Town & Country Planning Act 1990 (as amended)

Application for Planning Permission

Development Demolition of existing 3 bed dwelling & attached 2 bed bungalow, double garage, stable & outbuildings. Erection of 1 no. 5 bed dwelling with indoor swimming pool, 6 attached garages, plant room & gardener's store & garage

Location Tall Trees High Street Angmering

DETAIL existing elevations

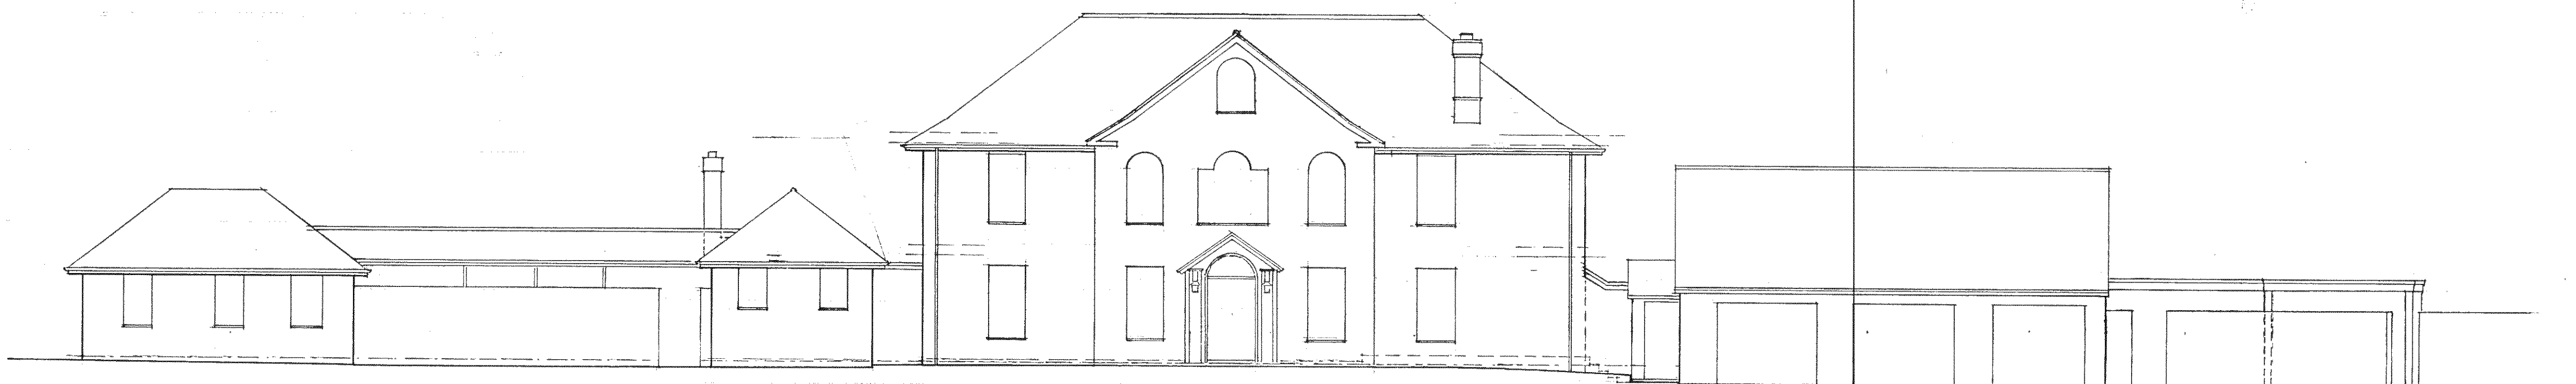
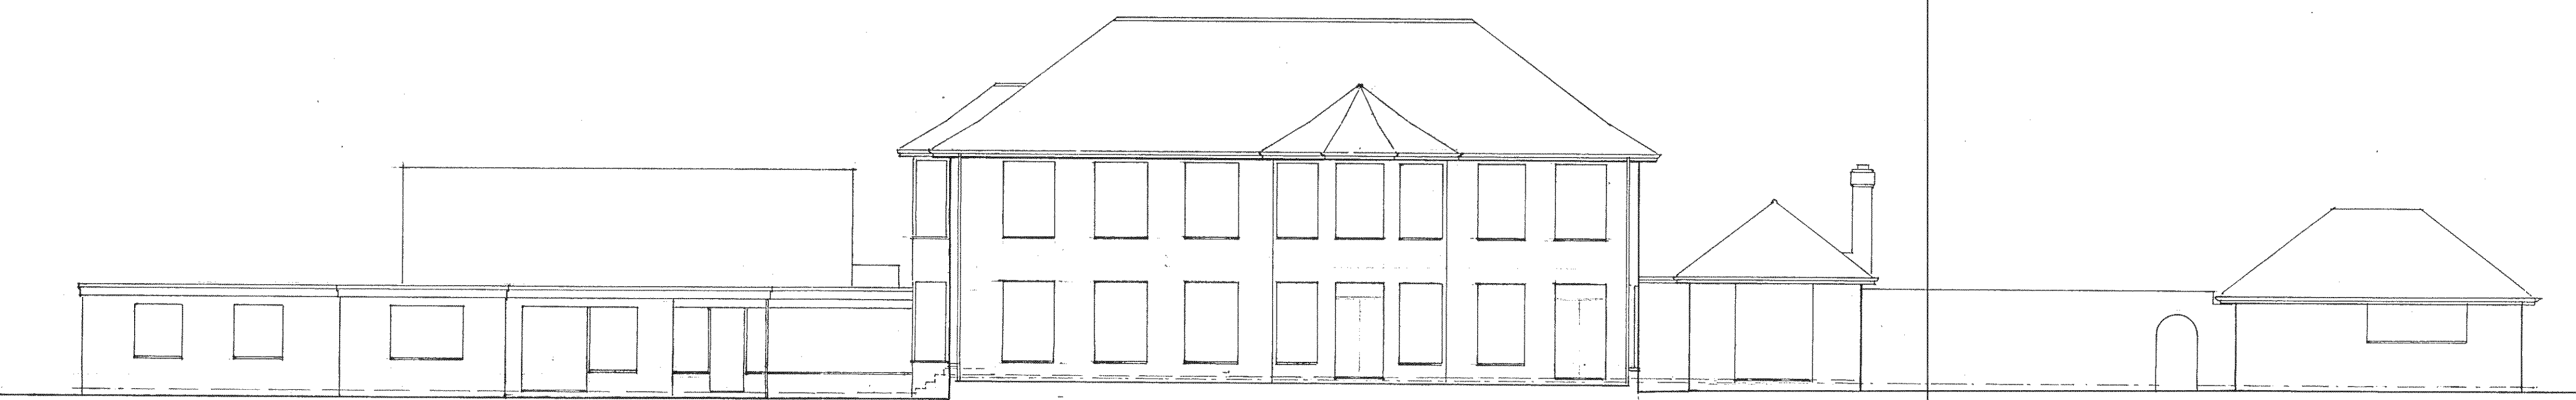
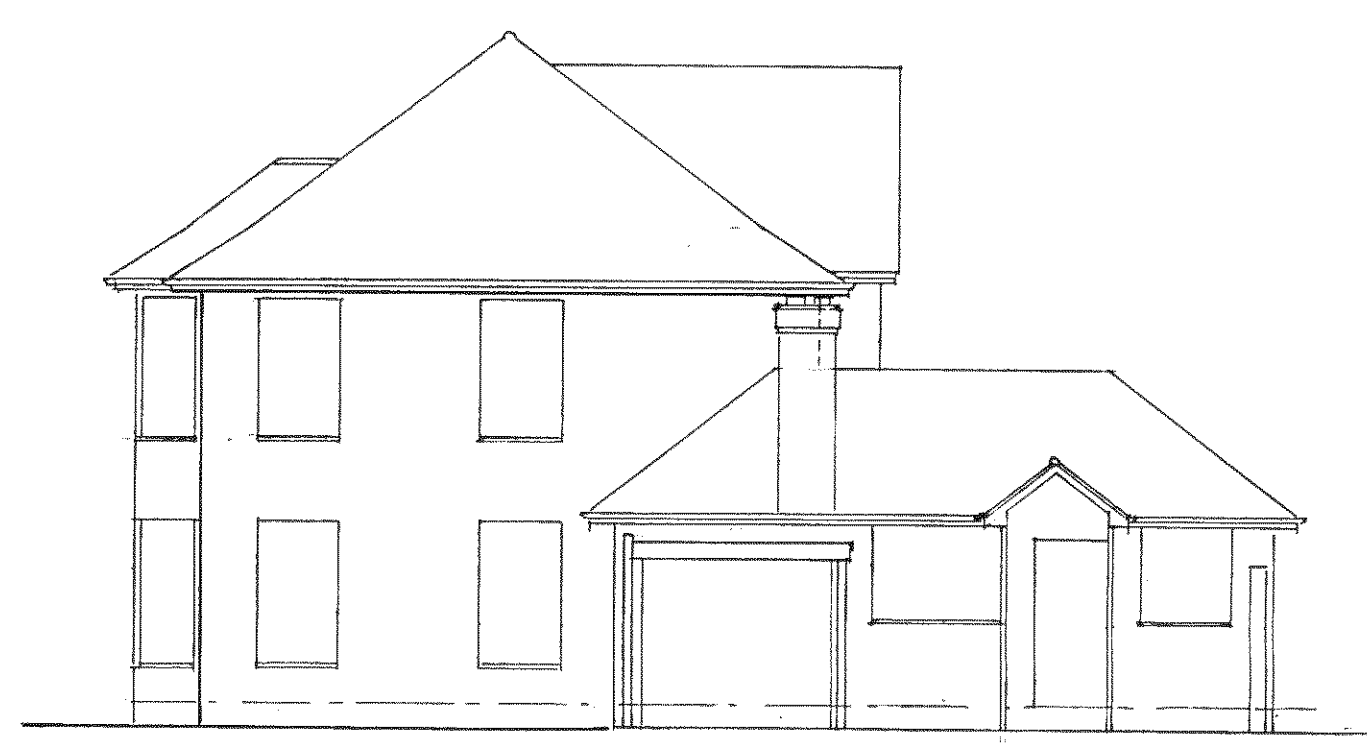
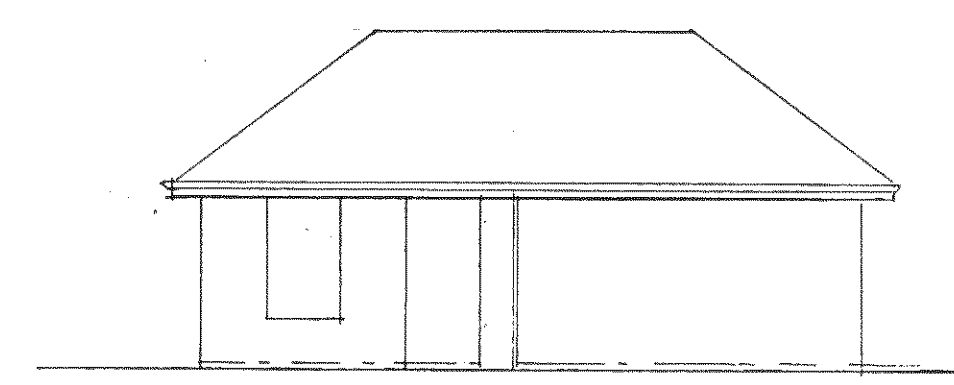
- The windows on the bungalow and games room on the existing ground floor plan do not match the the windows shown on the main dwelling. Please amend.
- There is a window on the existing front (north) elevation which is not shown clearly on the existing second floor plan (to match the other windows). Please amend.
- The existing east (side) elevation does not accord with the existing ground floor plan. Please amend.
- The log store on the existing west (side) elevation does not accord with the existing ground floor plan and the games room window is not shown on the floor plan. Please amend.
- The existing south (rear) existing elevation does not accord with the existing ground floor plan (games room windows do not match). Please amend.
